Address: 130 Mase St

CHECK-LIST AGAINST ZONING ORDINANCE

#080269

Proposed Use/Work - revised site plan for 2 extra dwelling units  
Attached

FRONT ELEVATION

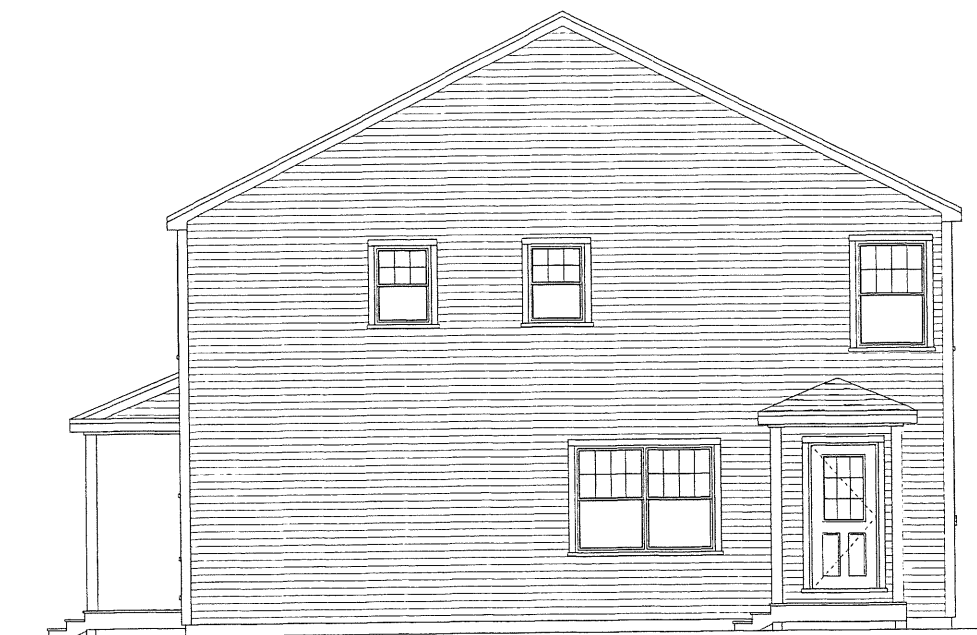
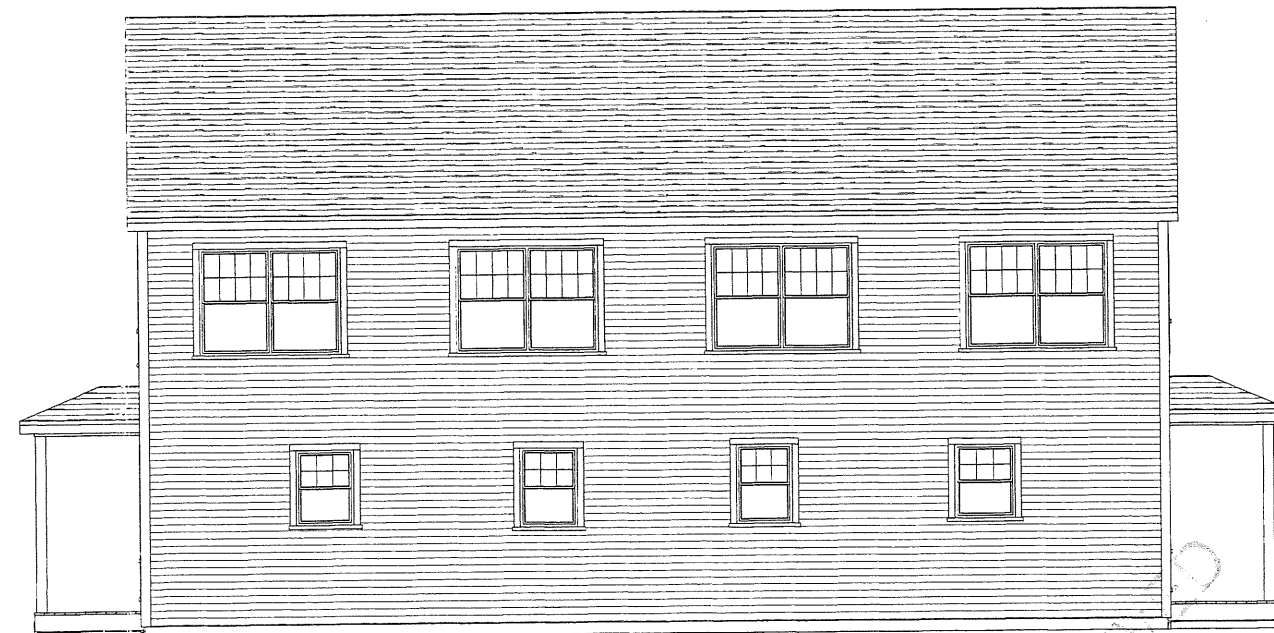
Height - 35' max - 31'6" given

SITE PLAN
AT
38 MORSE STREET, PORTLAND, MAINE
MADE FOR
ROBERT C. NELSON
47 ALICE COURT, PORTLAND, MAINE

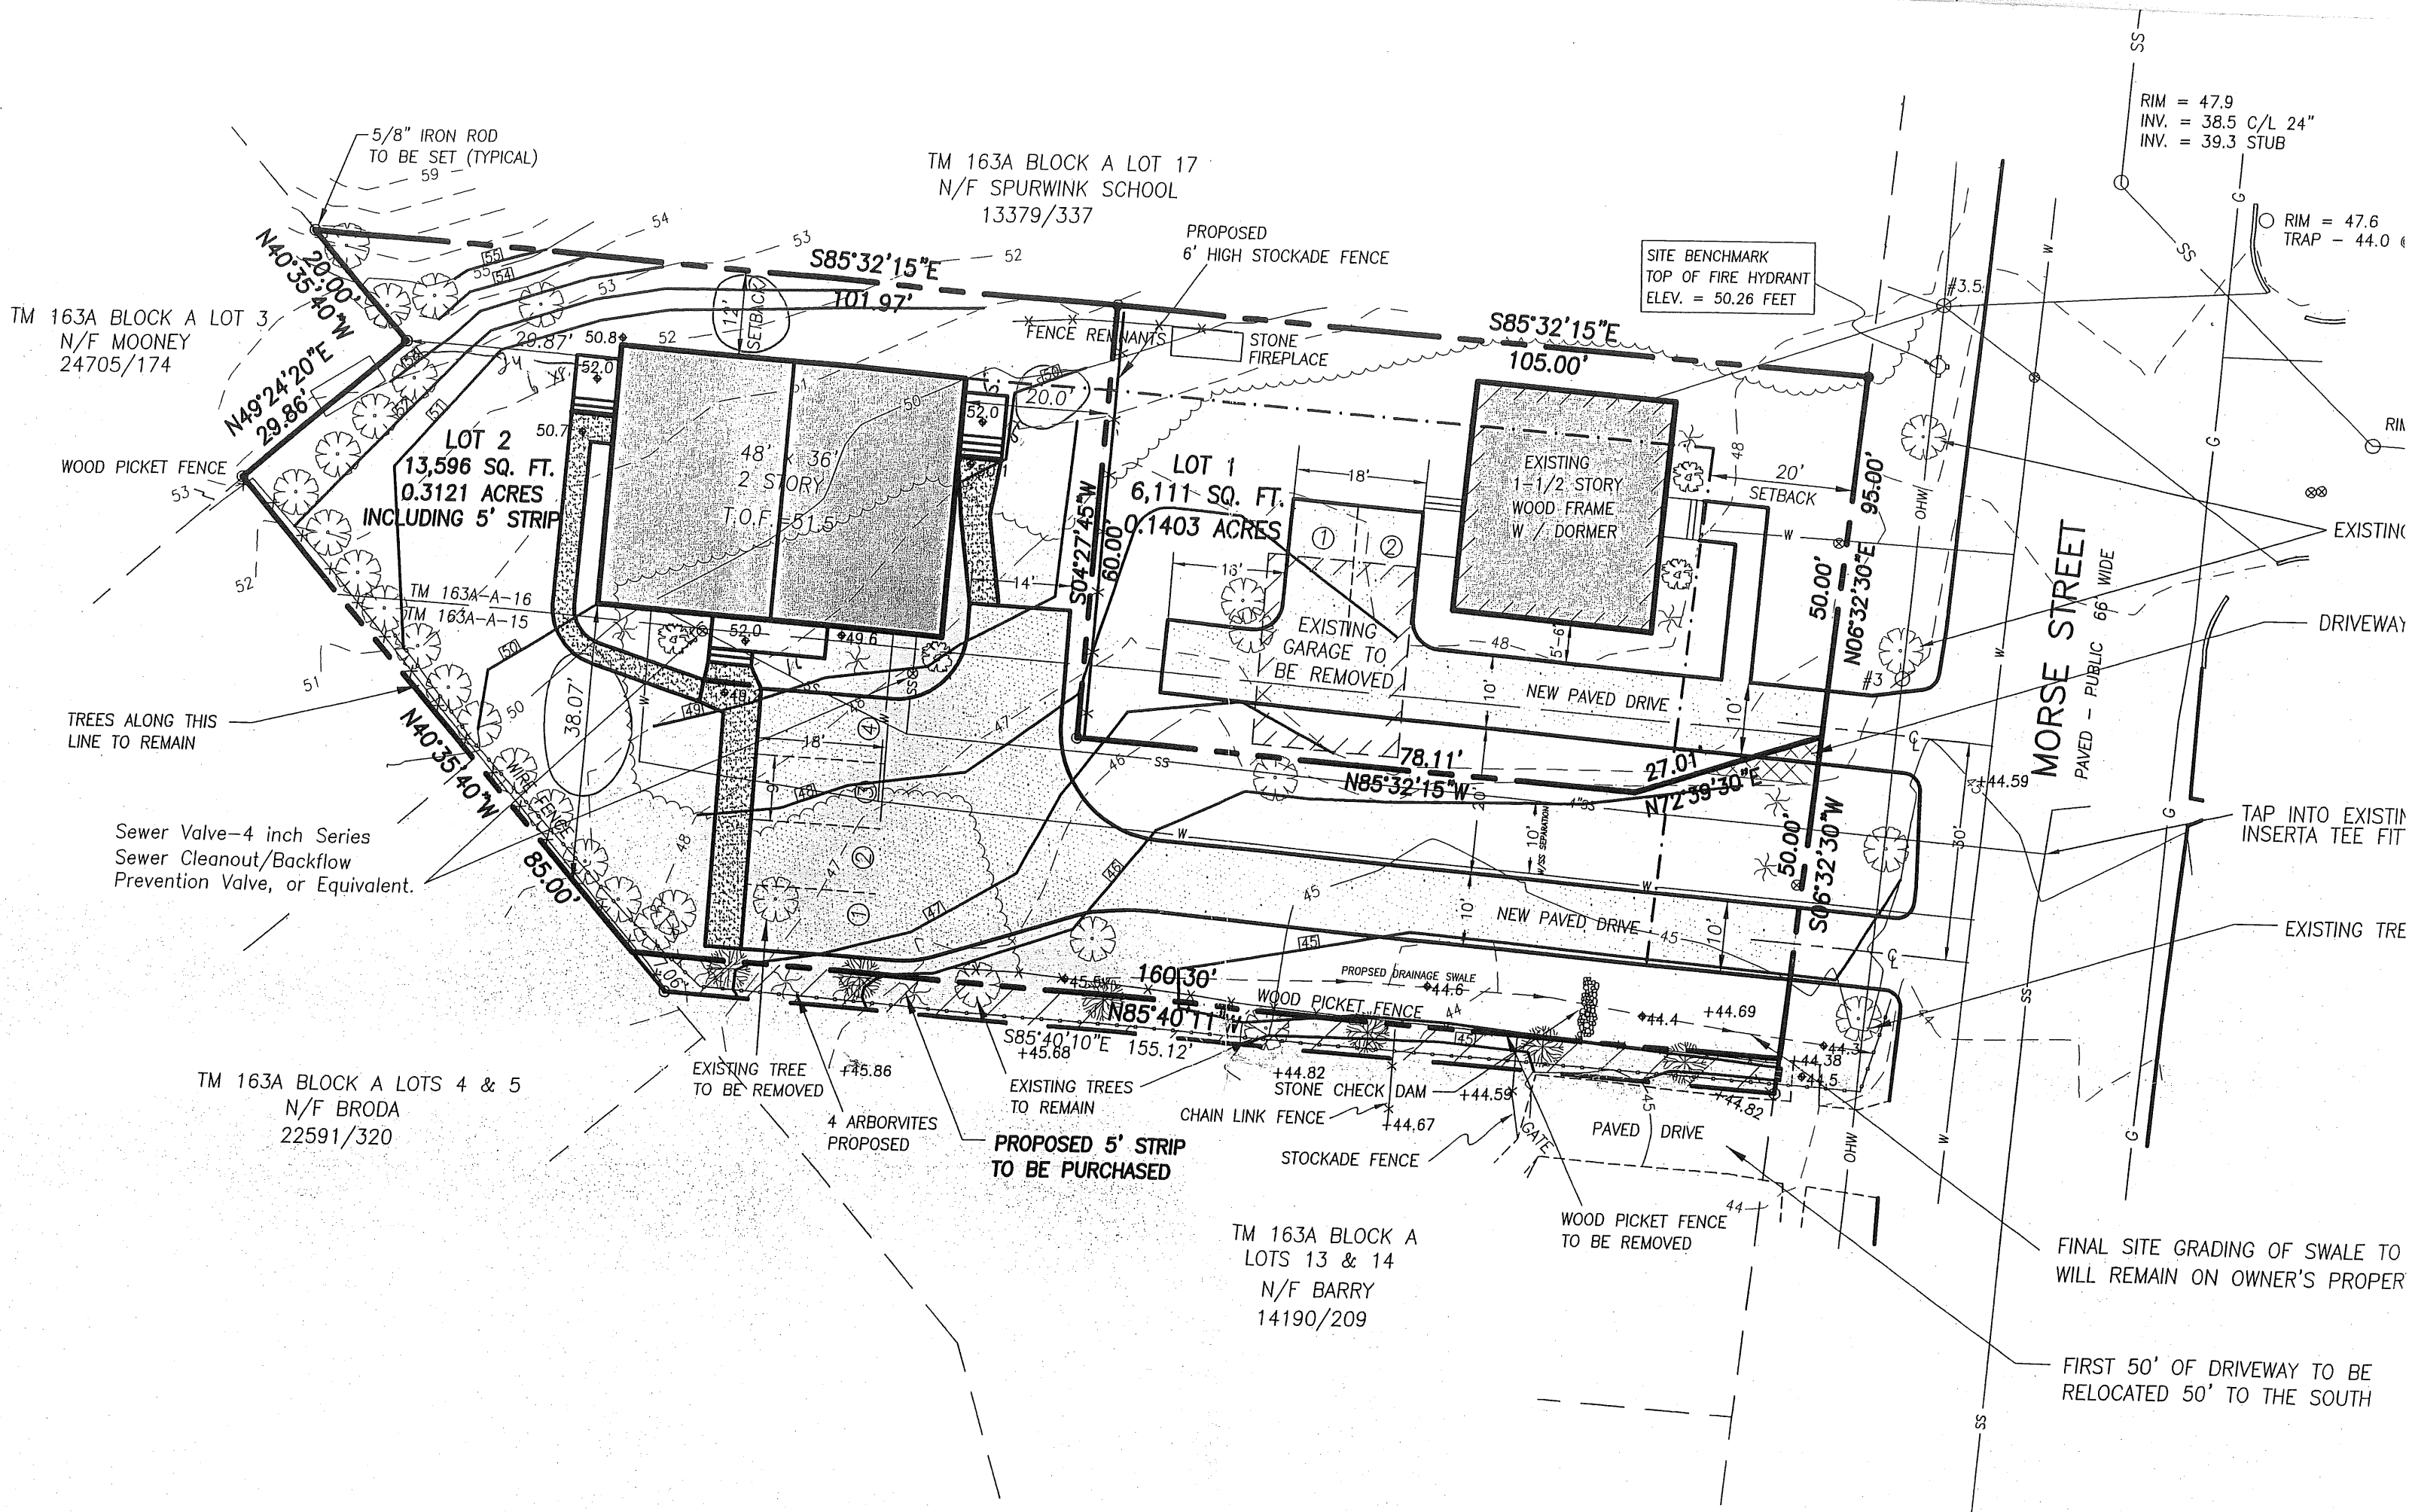
Lot Street Frontage - 50' min - 95' shown

Front Yard - 20' min - 20' to closest steps

Rear Yard - 20' min - 36' set back

Side Yard - 12' min - 12' & 15' given  
2 story

Width of Lot - 90' (multiplex) min - 95' shown

Lot Area - 18,000 $\pm$  min for multiplex - 18,919 $\pm$  given

Lot Coverage/Impervious Surface - 40% max - 38% given

Area per Family - 6000 $\pm$ /DU or 18,000 $\pm$  min - 18,919 $\pm$  given  
multiplex

Off-street Parking - 6 PKG SPACES - 6 shown
